**Re: Permit No COM2223,  
AT&T 10093745 Backup Generator CD**

We have received your plan review comments. Our responses to your comments are noted below:

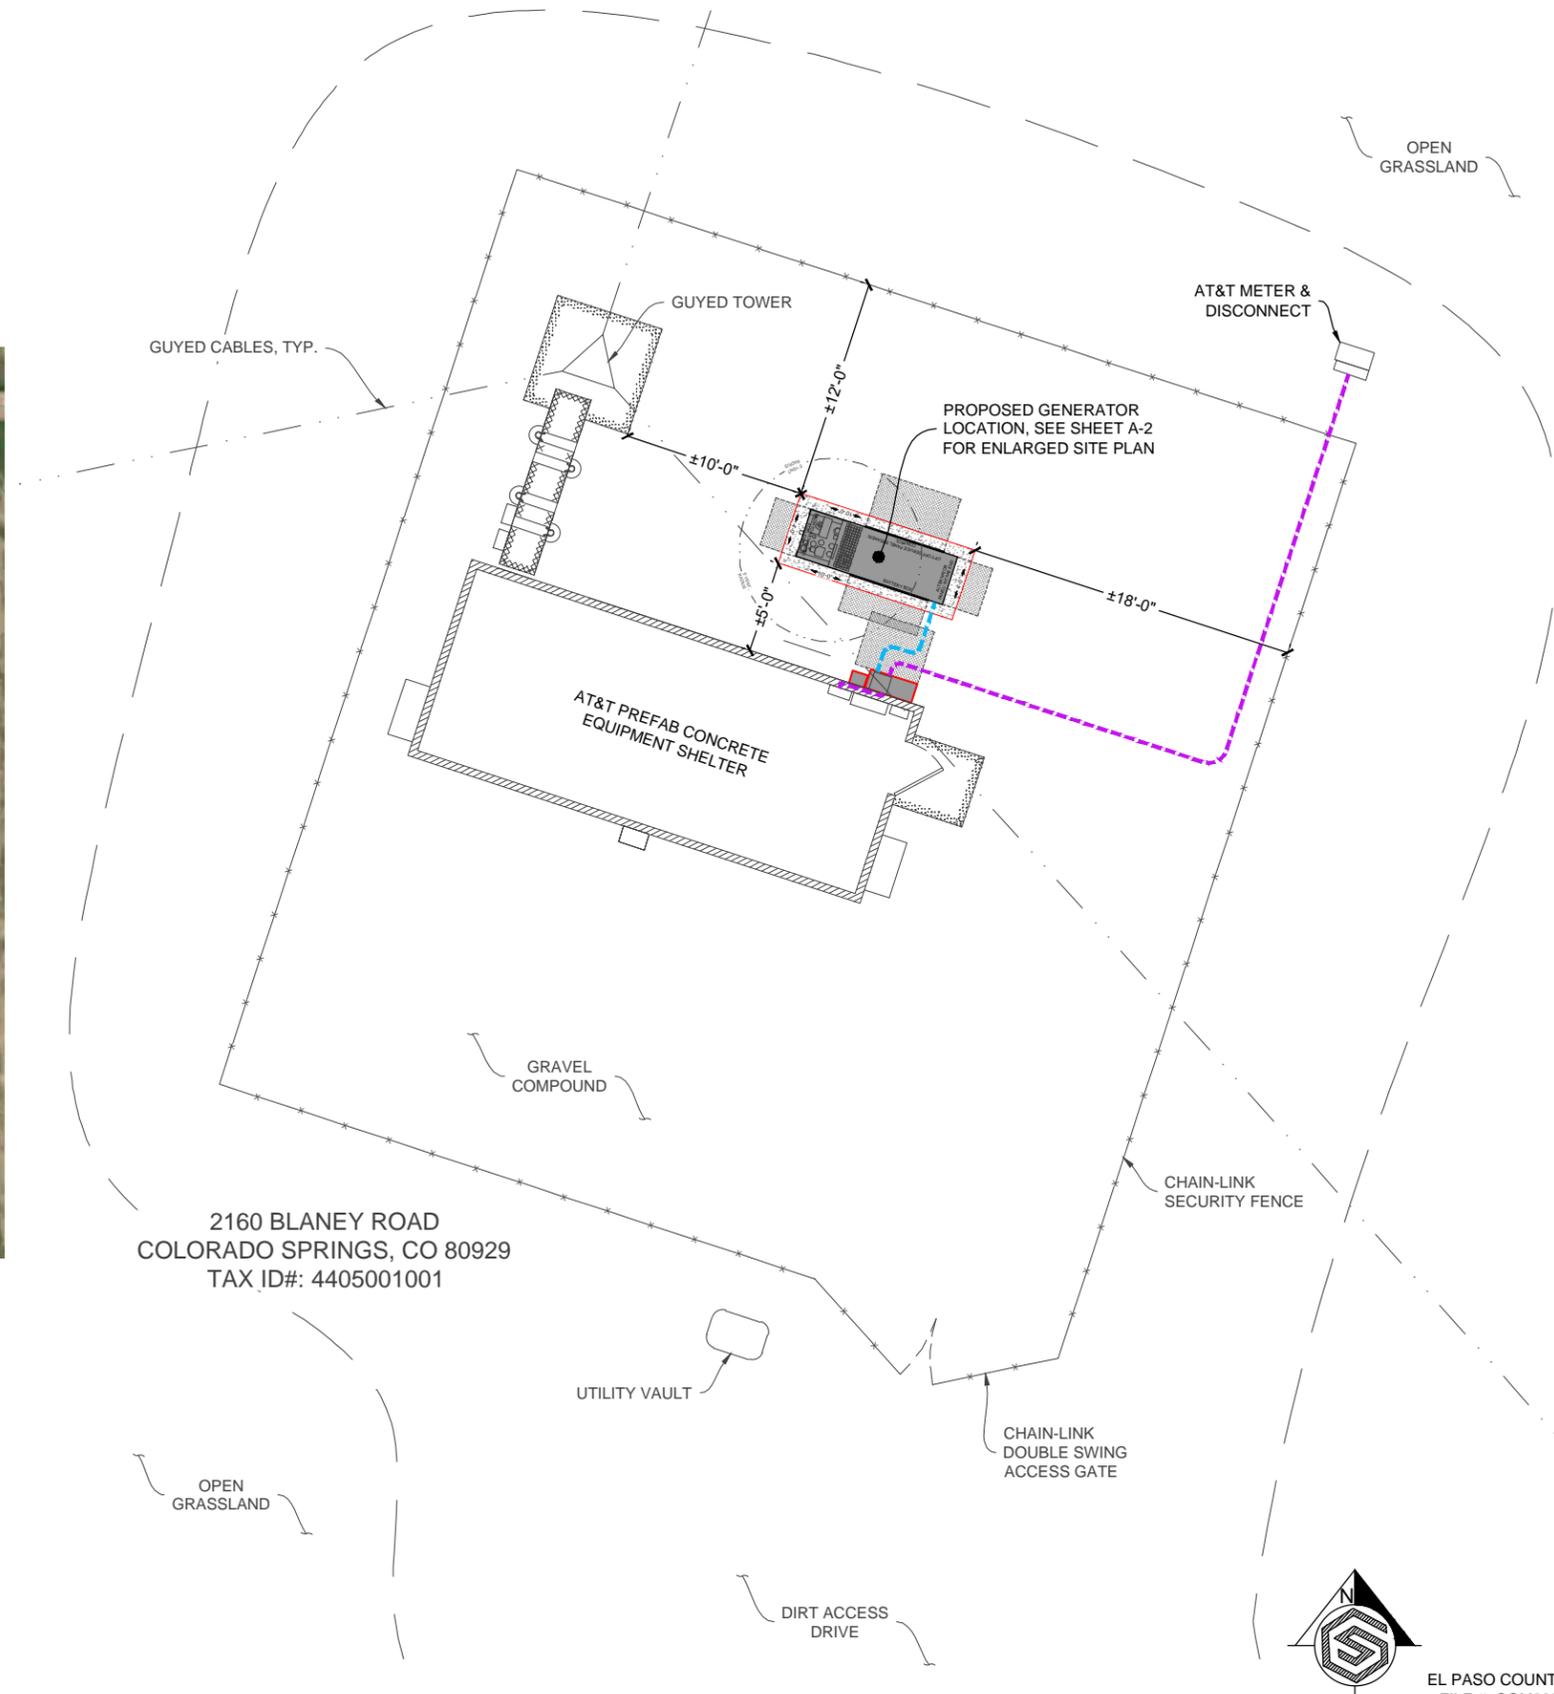
1. Revision clouds have been removed
2. A-1 sheet has been updated as requested
3. Tower to property line distances have been added to A-1
